**NEW EPPING SOUTH PRIMARY SCHOOL**  
**Application No SSD-8873789**  
**RE: Submission by residents of Second Avenue**

Figure 30 Proposed civil works to Grimes Lane (Source: PTC)

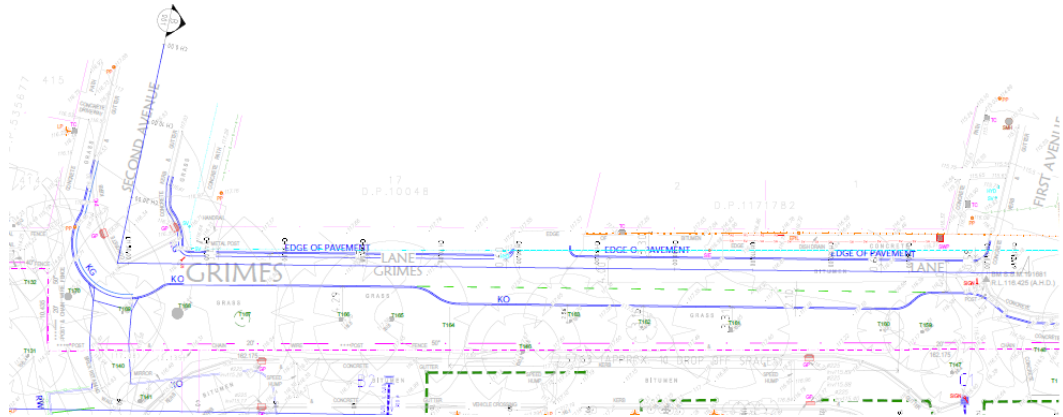
**We are adamant denial of all 24/7 motor vehicle access between Grimes Lane and Second Avenue remains in perpetuity.**

- Two-way motor vehicle access already exists for the present paved width of Grimes Lane. Surely it is adequate to accommodate two-way traffic for low speed motor vehicle access to school parking and 3 local properties.
- Motor vehicle traffic which presently ignores two NO THROUGH ROAD signs at the entrance to Second Avenue will also ignore the proposed one-way westbound restriction for Grimes Lane. Having reached the end of Second Avenue it would be naive to suggest motorists will return to Dunlop Street when they can see an escape route, even if it is illegal to use it that way. A serious accident could occur here as sight distance is severely restricted by a property boundary fence.
- Apart from pedestrians and cyclists, motor vehicles should only use Grimes Lane for school parking and access to 3 residential properties and **not** as a 24/7 through road.

- There is ample space between trees in Grimes Lane to provide 90° angle parking in accordance with Australian Standard AS 2890 without the need to remove any of them. See plan on page 3.
- More parking spaces can be provided for "kiss and ride" with 90° angle parking than parallel parking, easing some pressure on local street parking. On page 2 paragraph 2 of the STC response it states 20 parking spaces are required yet only 13 can be provided by parallel parking. By providing 90° angle parking 23 parking spaces can be achieved.
- There should be no conflict between school carpark traffic and "kiss and ride" traffic because both sets of traffic would use Grimes Lane at separate times. Teaching staff arrive before the pupils and leave after them.
- Construction of the above access would be far less expensive, easier to build, and will not affect present on site car park design.

- By providing school carpark access from Grimes Lane there would be no need to change the present conditions at the end of Second Avenue.

- Even with 90<sup>0</sup> angle parked vehicles in Grimes Lane there is sufficient residual width for a footway between parked vehicles and the site boundary.
- Retaining the existing denial of motor vehicle access between Grimes Lane and Second Avenue will eliminate pedestrian/motor vehicle conflict at the western end of Grimes Lane for Second Avenue “kiss and ride” pupils.
- If pedestrian/vehicle conflict is an issue near the First Avenue entrance the provision of a “lolly-pop” person could overcome this problem.
- Similar pedestrian/motor vehicle conflicts exist at some shopping centre car parks throughout the day not just at school start and finish times and with larger traffic volumes.
